Response to Planning Application

Application ref: BE/23/25/DOC

Description: Approval of details reserved by condition imposed under reference BE/150/22/OUT relating to condition number 7 - landscaping and layout.

Location: Land at Oldlands Farm Newlands Road Bognor Regis PO22 9NN

DRAWING TITLE
**DETAILED PLANTING PLAN
(Sheet 1 of 2)**

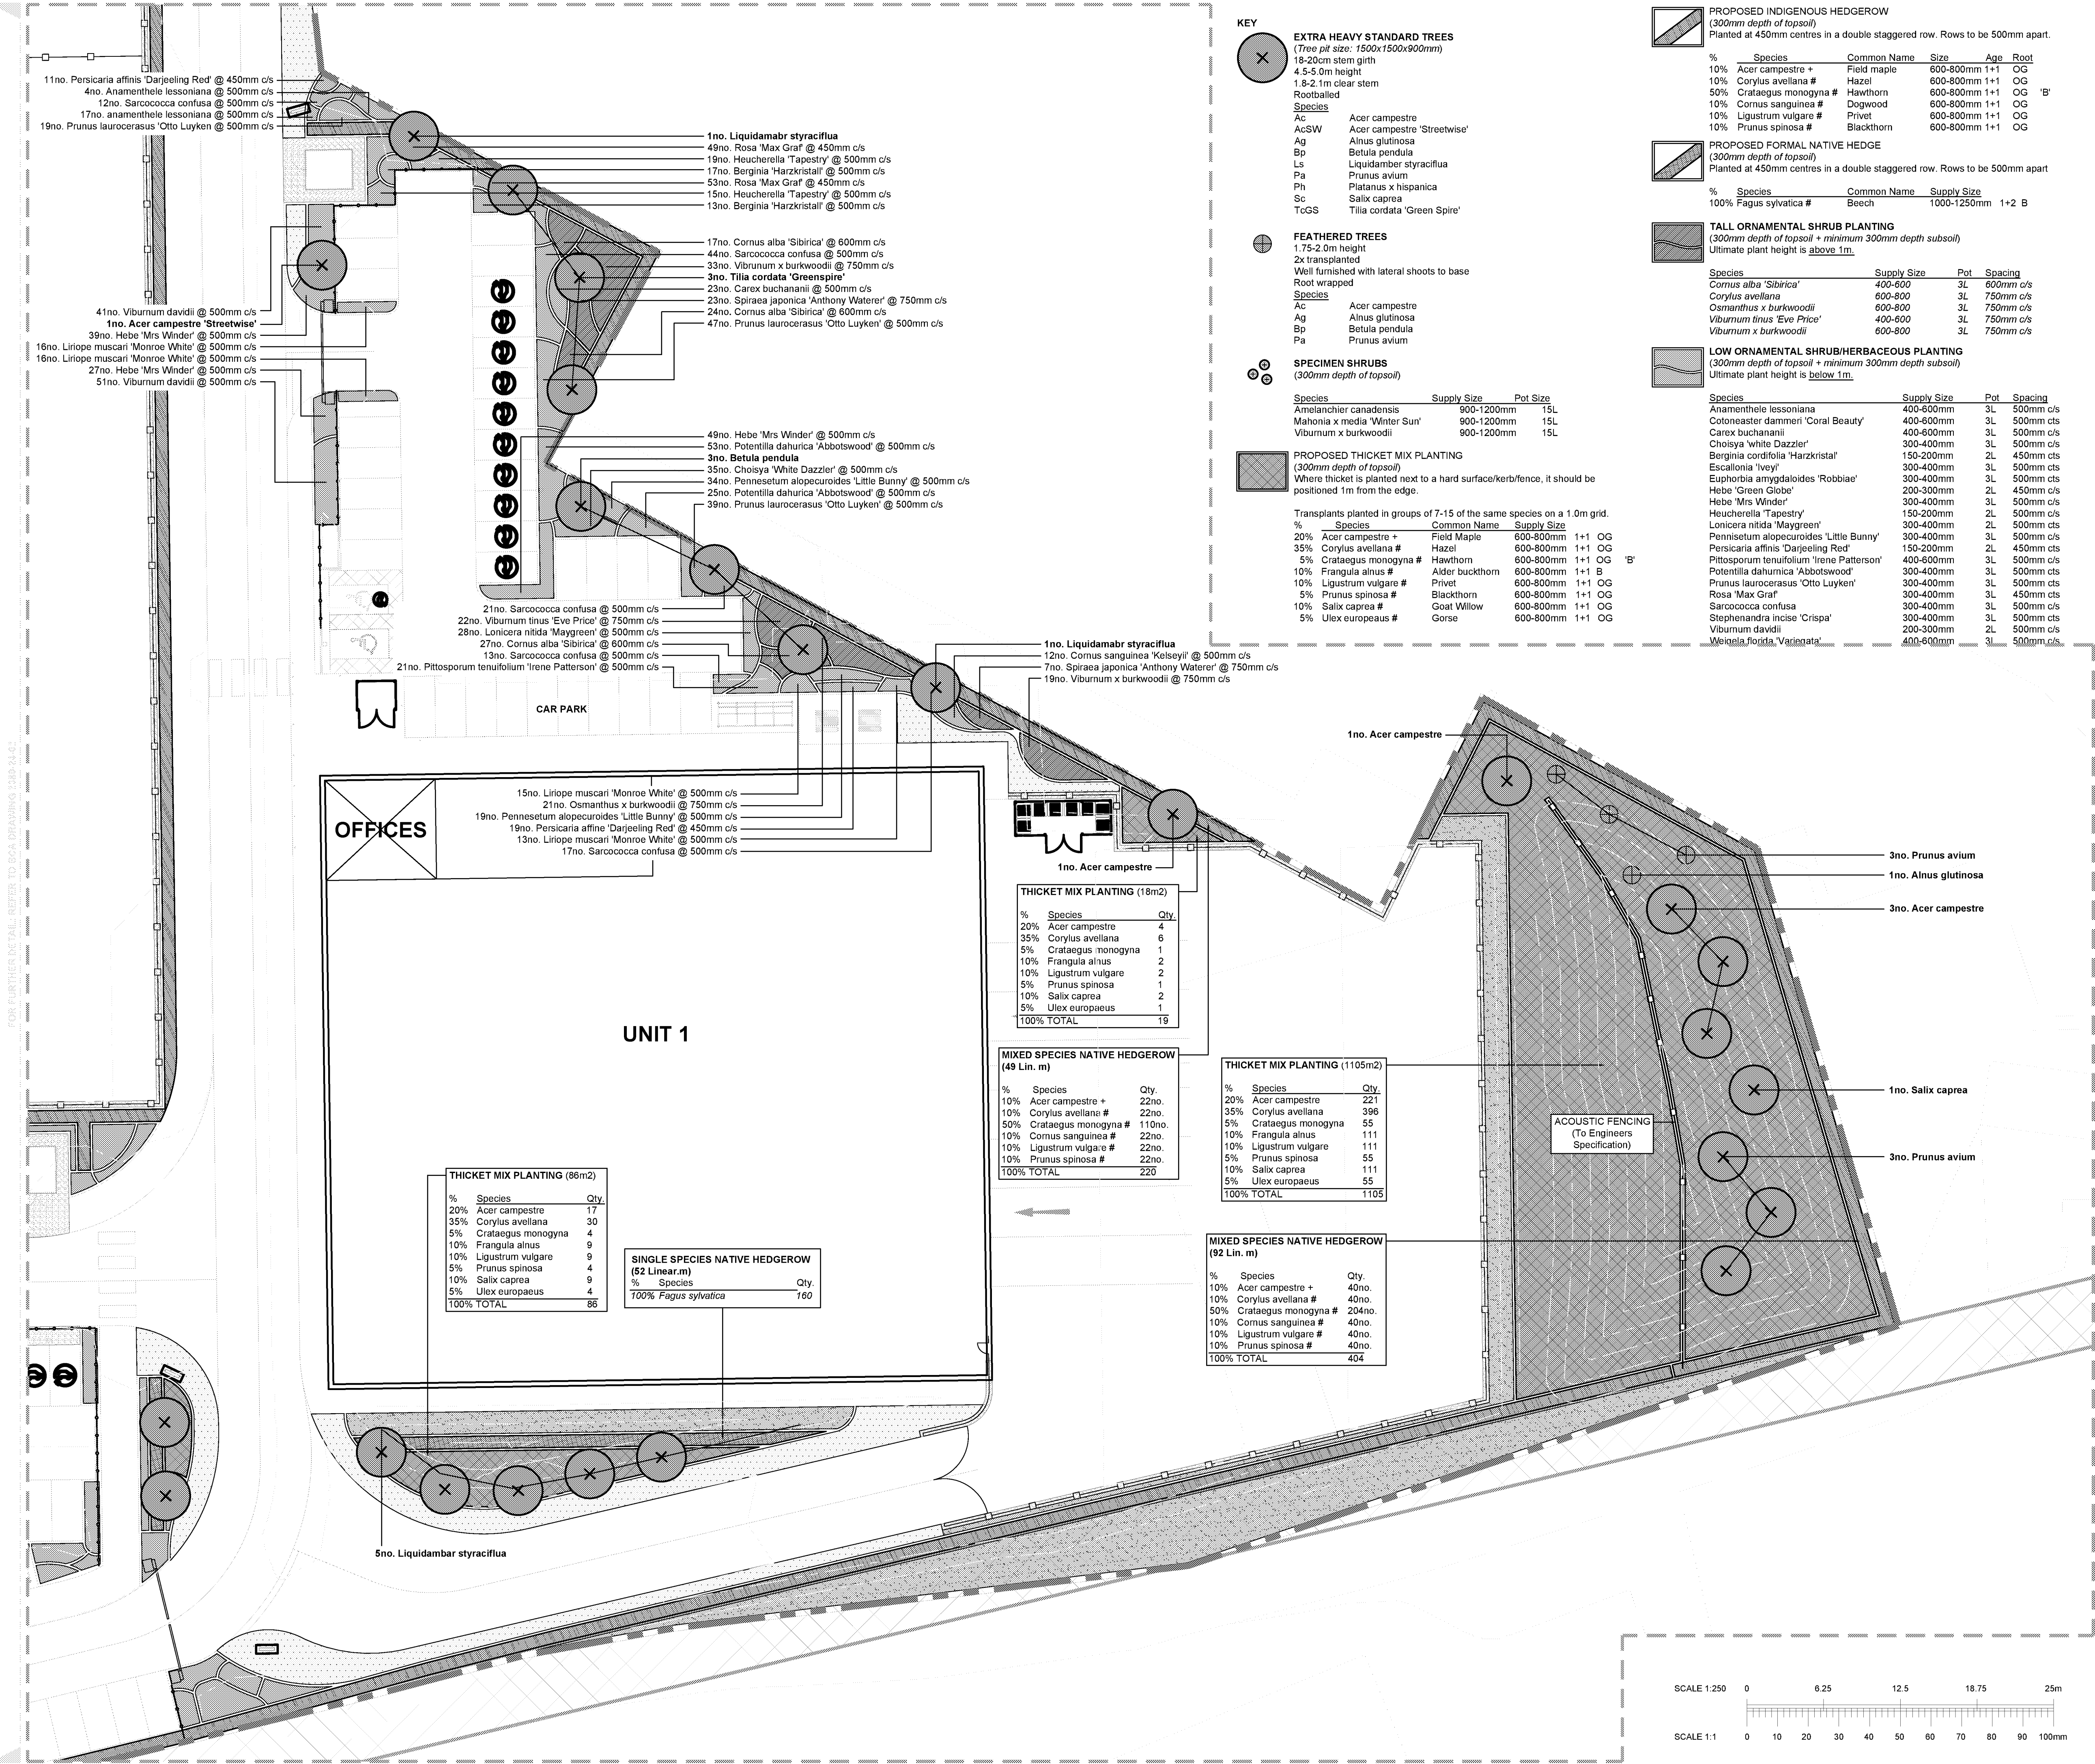
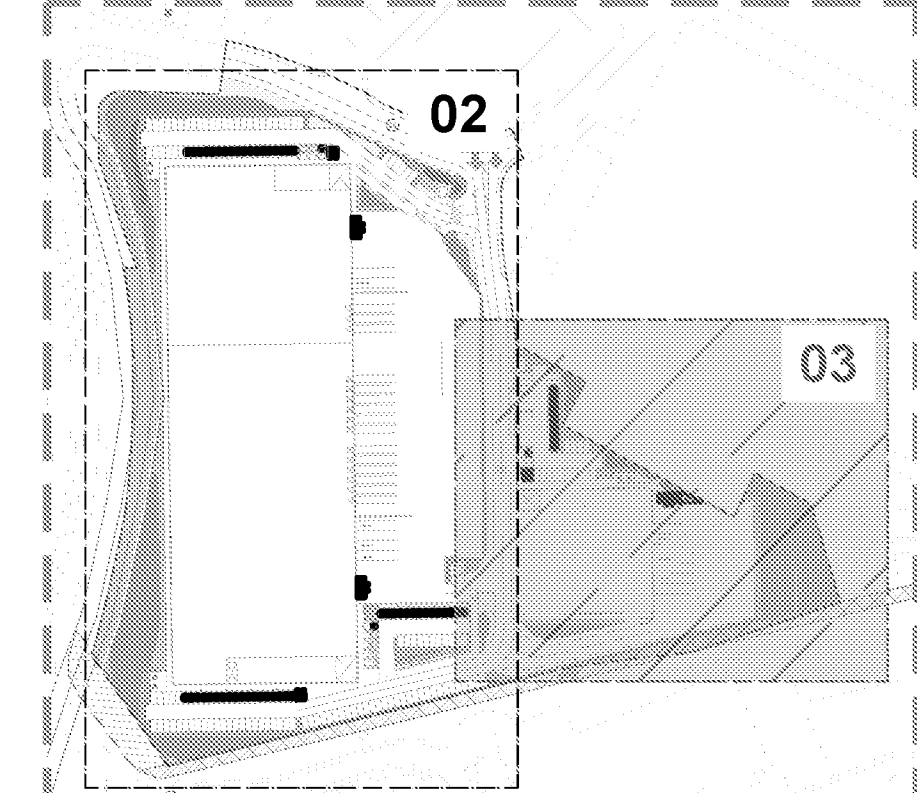
The landscape detail has been amended to cater for the incorporation of SuDS features within the scheme. The landscaping will largely be unaffected by the incorporation and certainly not detrimentally so. It does need flagging however that there would appear to be conflict with 3no proposed trees which appear to be within the 3m offset required to the SuDS. These are 1no Acer campestre 'Streetwise' to the west of the northern SuDS area and 2no Tilia cordata 'Greenspire' to the north of the northern SuDS area – these trees can remain but need to be repositioned if not already shown to allow a minimum 3m offset. (for avoidance of doubt this amend should be confirmed in plan form)

As discussed, the updated Detailed Planting Plan Sheet 2 of 2 reflecting the 3 proposed trees that have been re-positioned to avoid the SUDS, is attached.
